DETERMINATION OF MAJOR PROJECT NO. 06_0301

**ALTERATIONS AND ADDITIONS TO CHATSWOOD CHASE SHOPPING CENTRE
AT 345 VICTORIA AVENUE, 19 HAVILAH STREET AND 8 MALVERN AVENUE,
CHATSWOOD**

RECOMMENDED CONDITIONS OF APPROVAL

MALVERN AVENUE CARPARK ENTRY

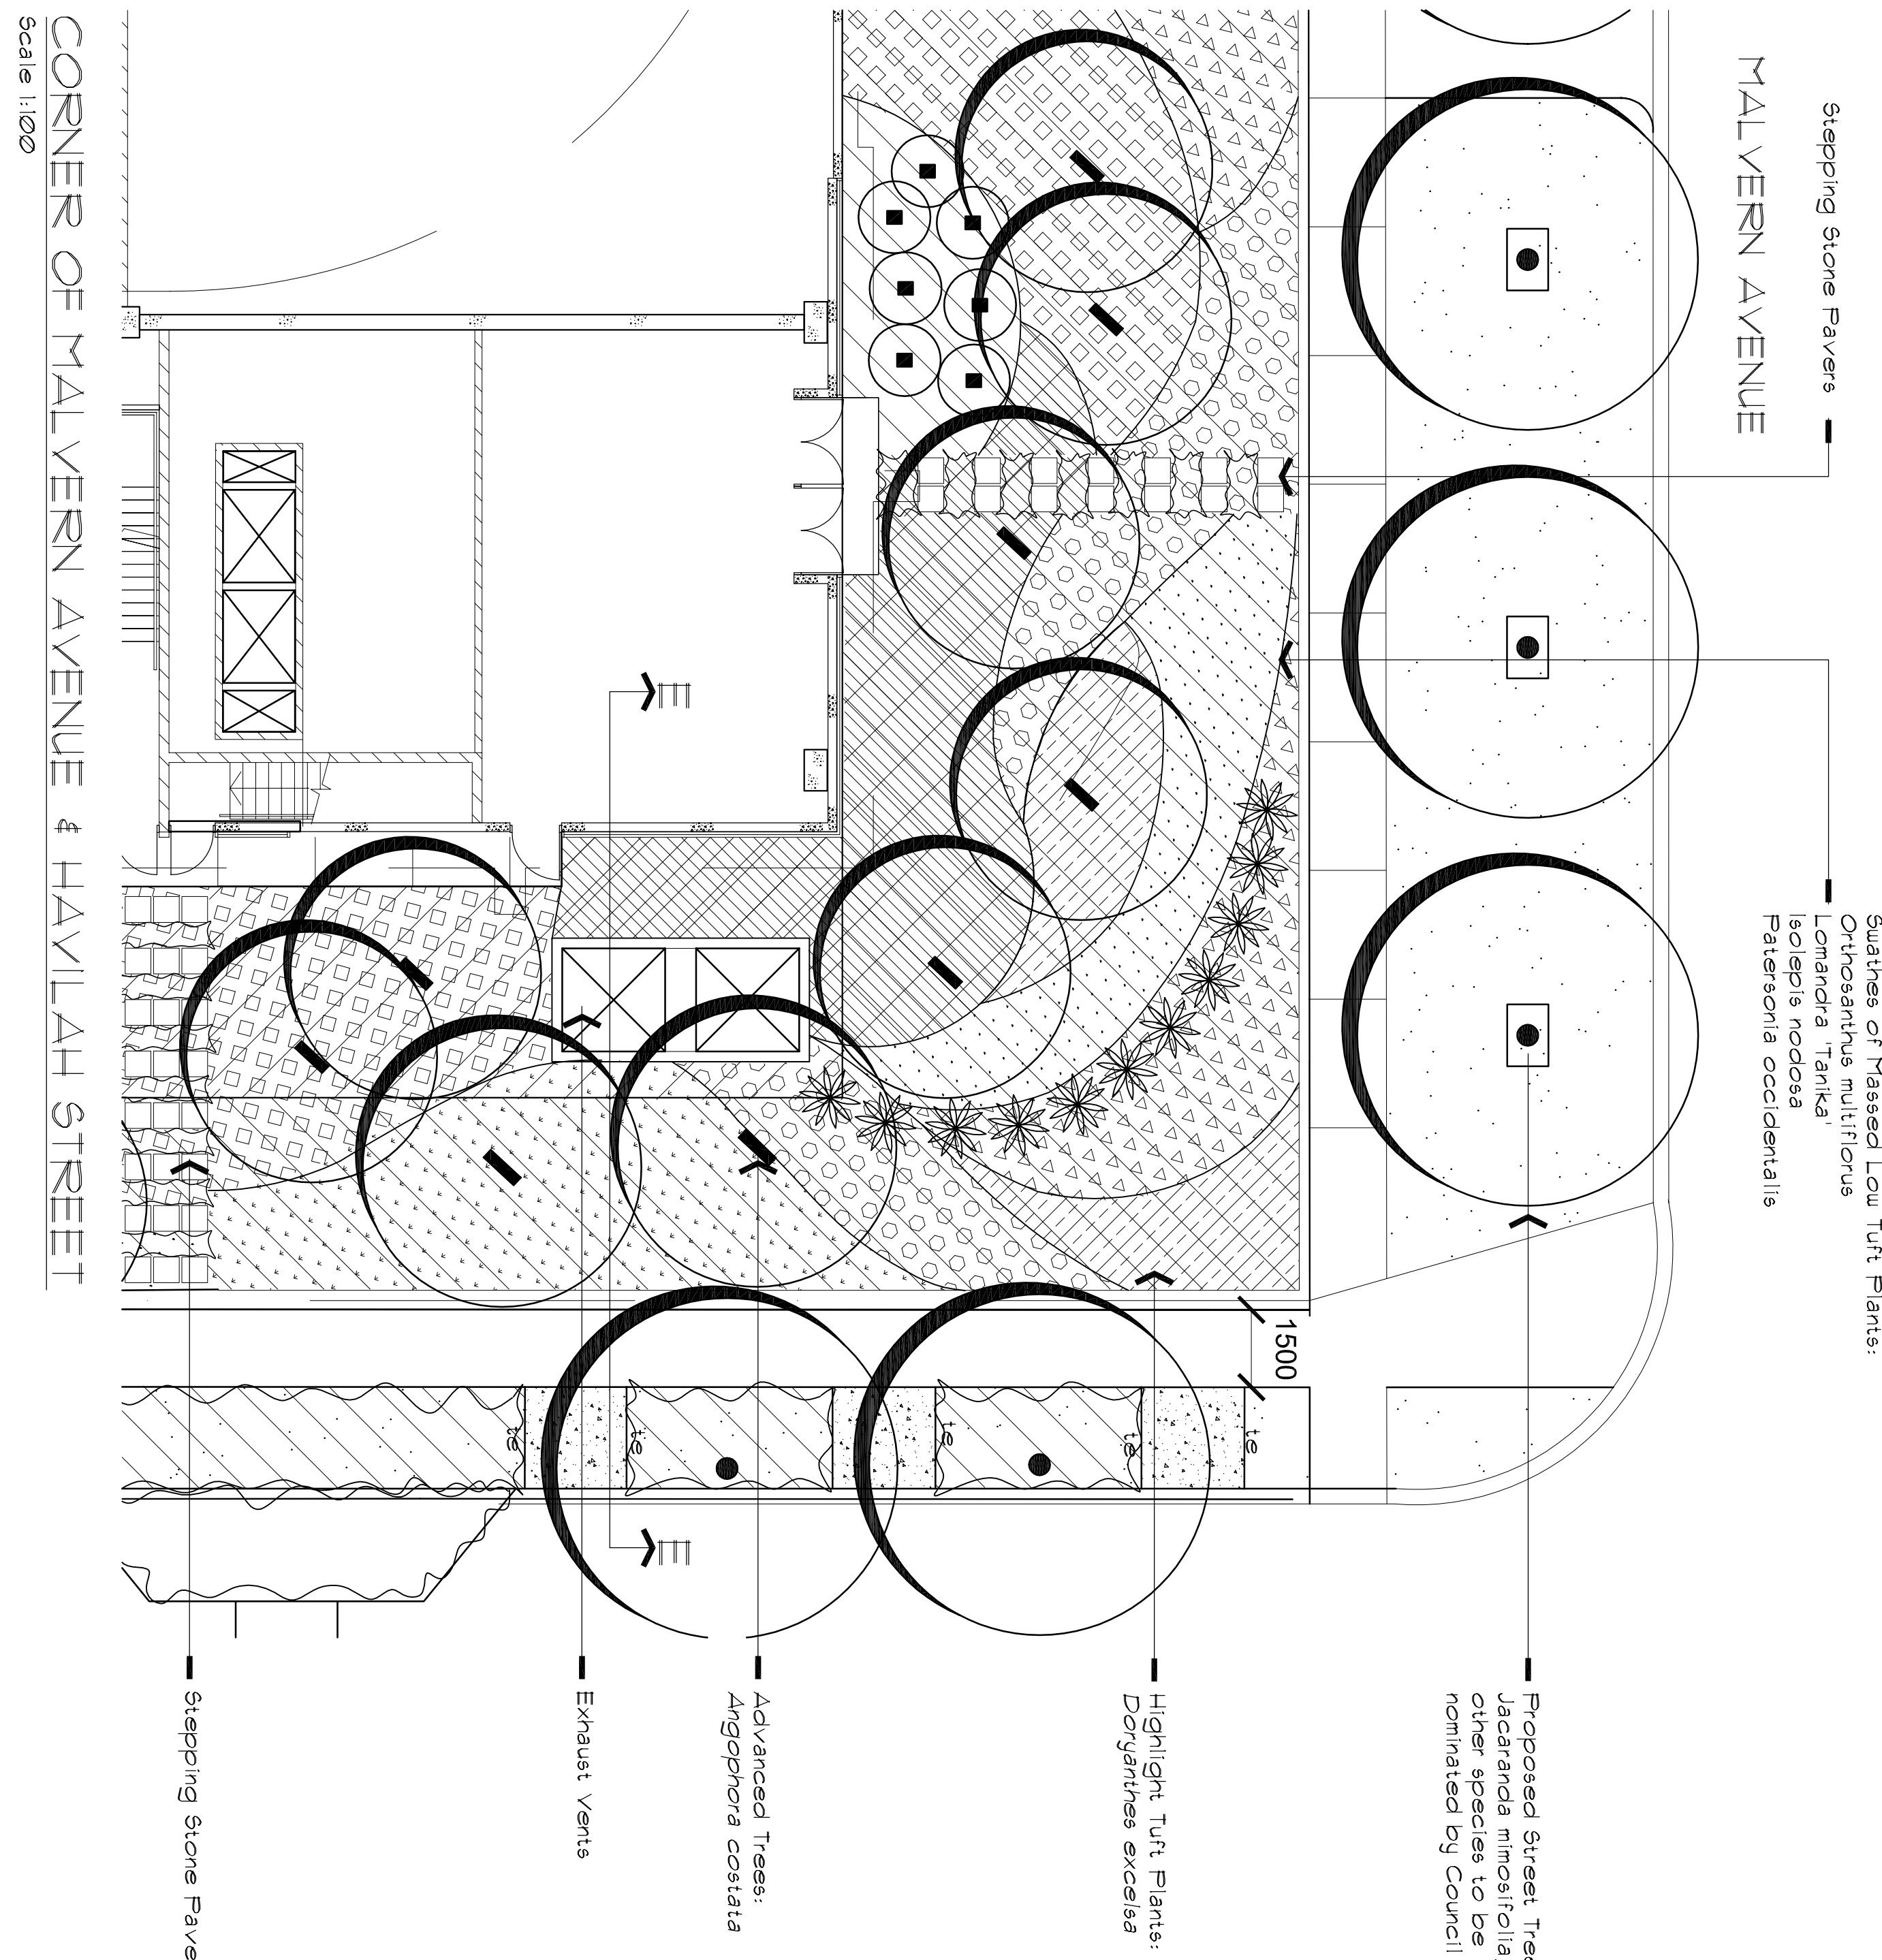
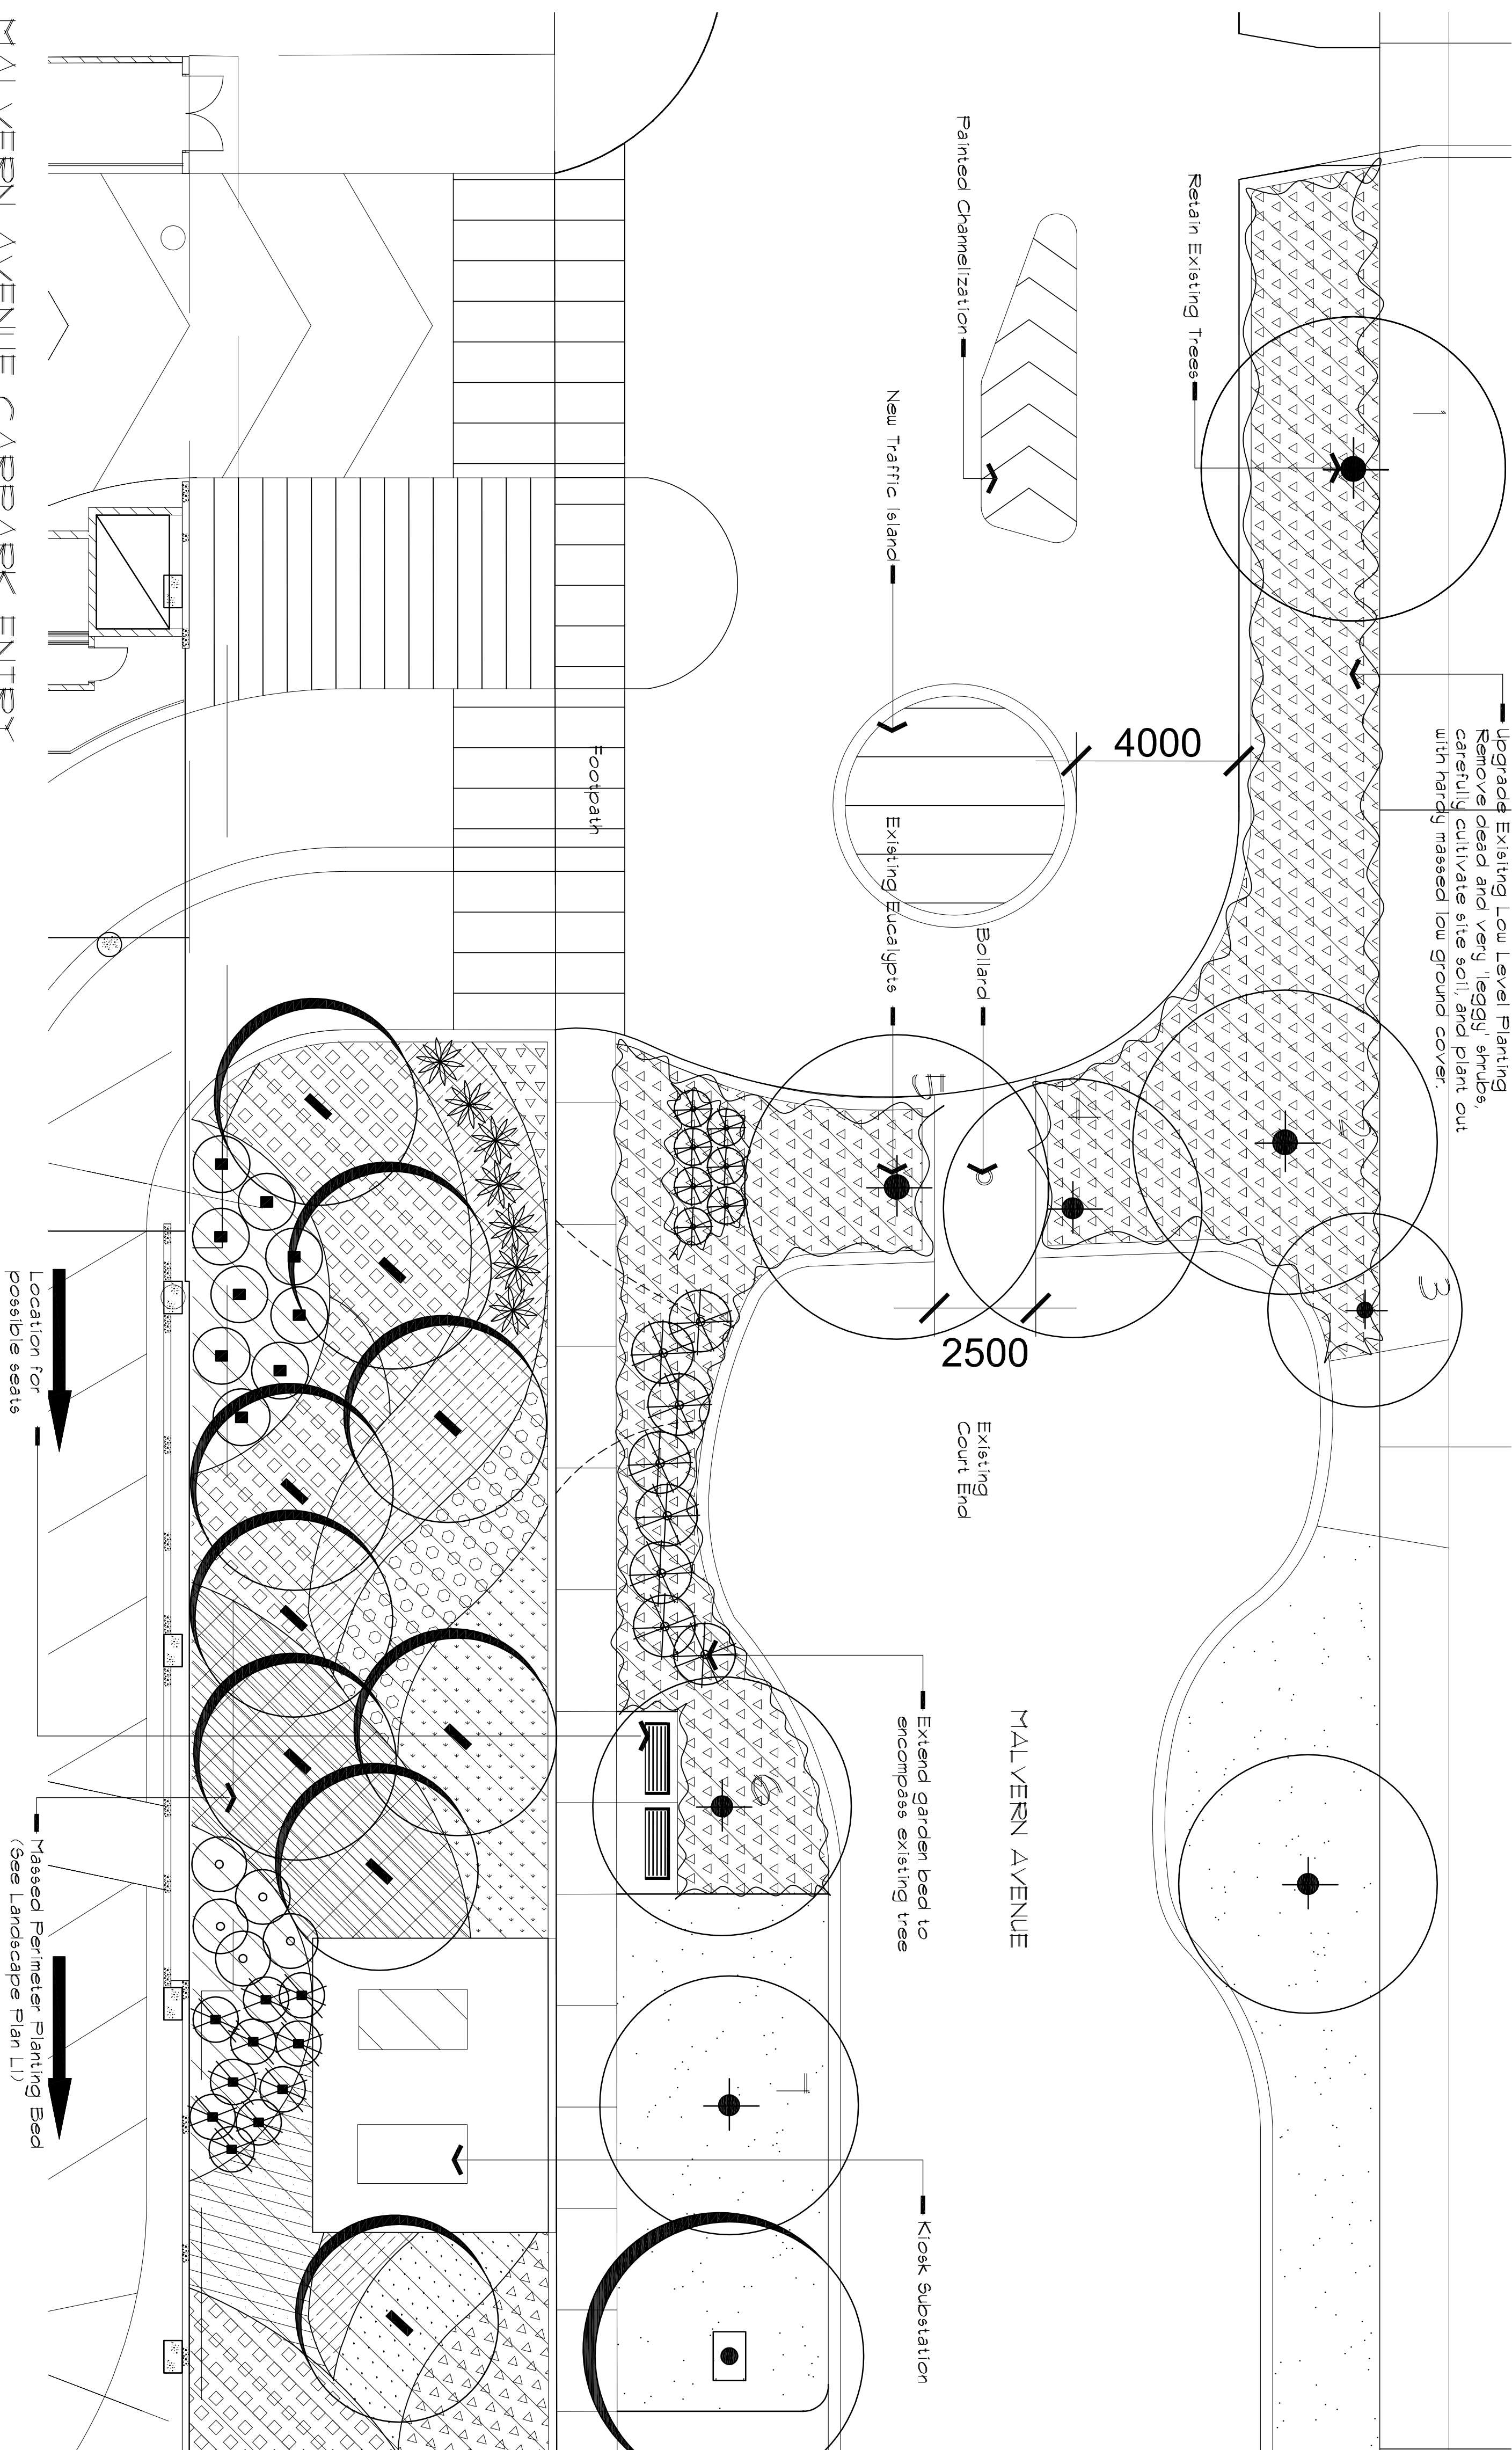
The Landscape Plan is to be amended prior to Construction Certificate CC2 to provide for street trees in Havilah Street and Malvern Avenue as follows;

- *Angophora costata* shall be provided in Havilah Street,
- *Michelia doltsopa* shall be provided in Malvern Avenue.

HAYLATH STREET ENTRY

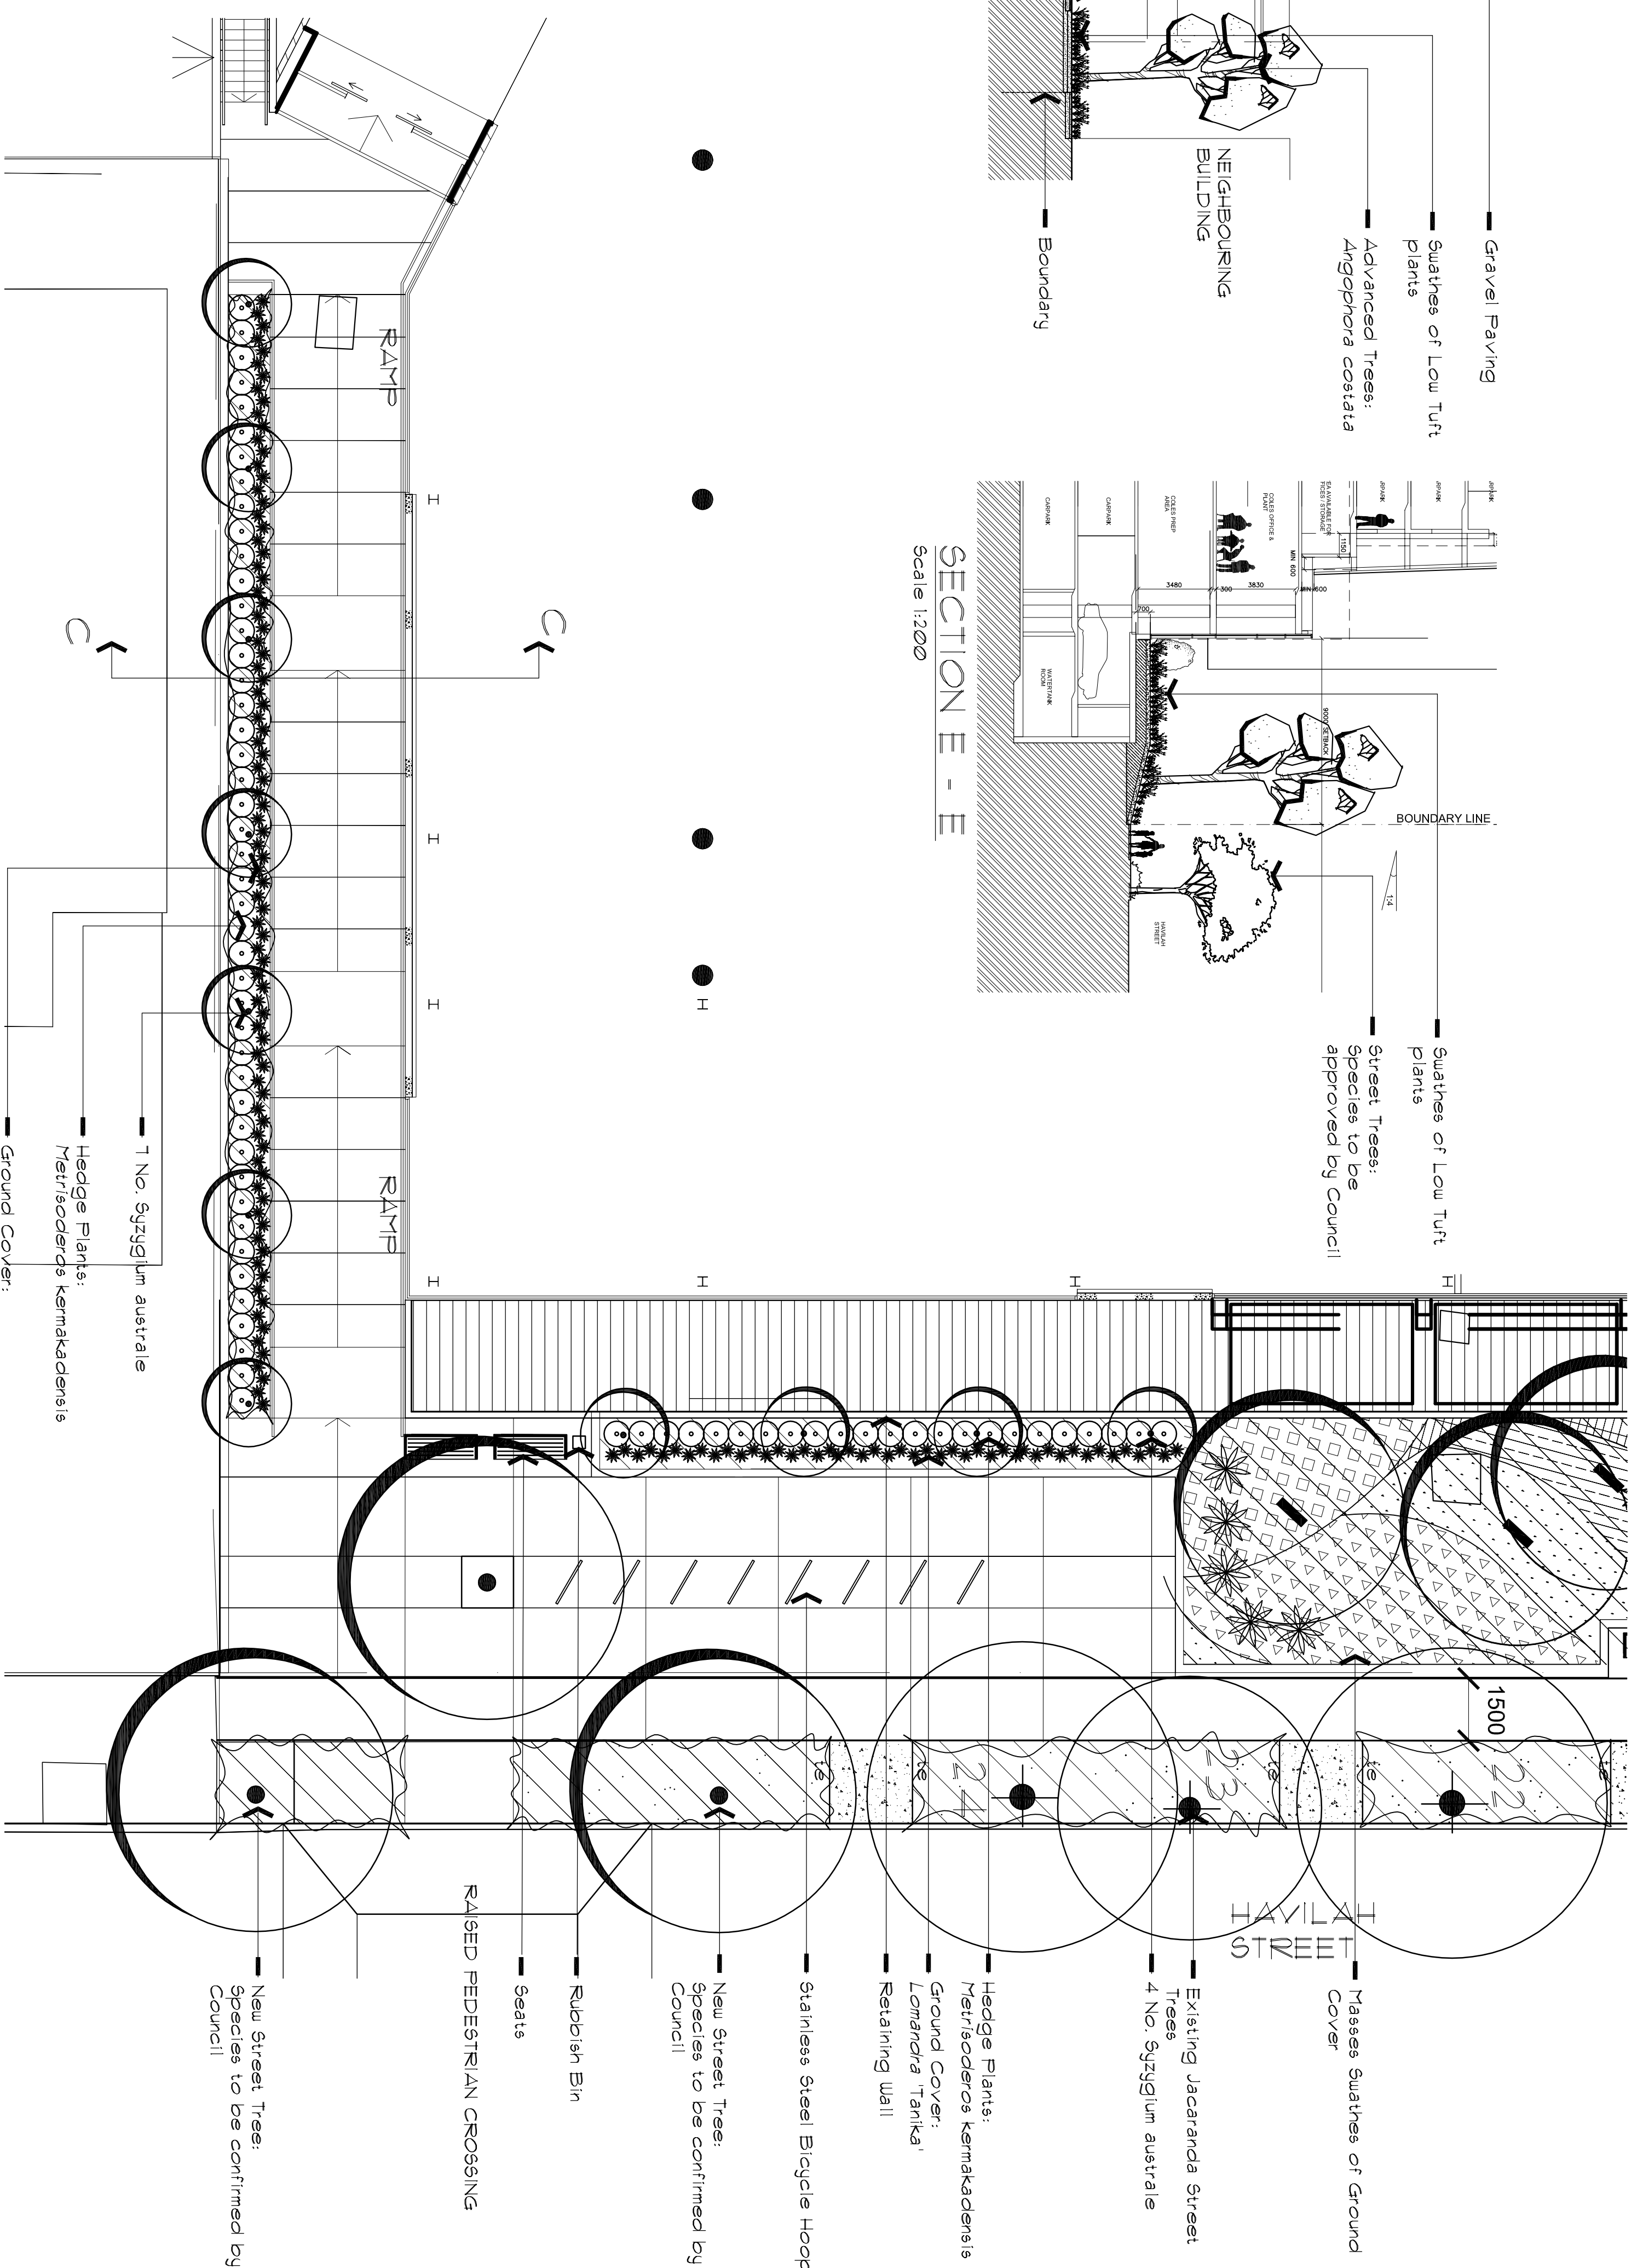
- (2) Redesign of the pedestrian entry from Havilah Street to achieve unimpeded view lines from the street to the entry doors, address security, privacy and noise issues. This is to be achieved by widening the link to a total of 6 metres and 2 metres width of buffer landscaping and a splay to the entry corner. An alternative design that achieves the objectives may be considered involving full enclosure of the walkway

- i) a 2 metre width glazed awning projecting from the building over the path for weather protection;
- ii) a gate at the point of the corner splay that is to be locked outside trading hours; and
- iii) a 2.5m masonry boundary fence along the southern edge of the walkway with a 2 metre high translucent glazed acoustic screen on top for the length of the building at 5-7 Havilah Street.
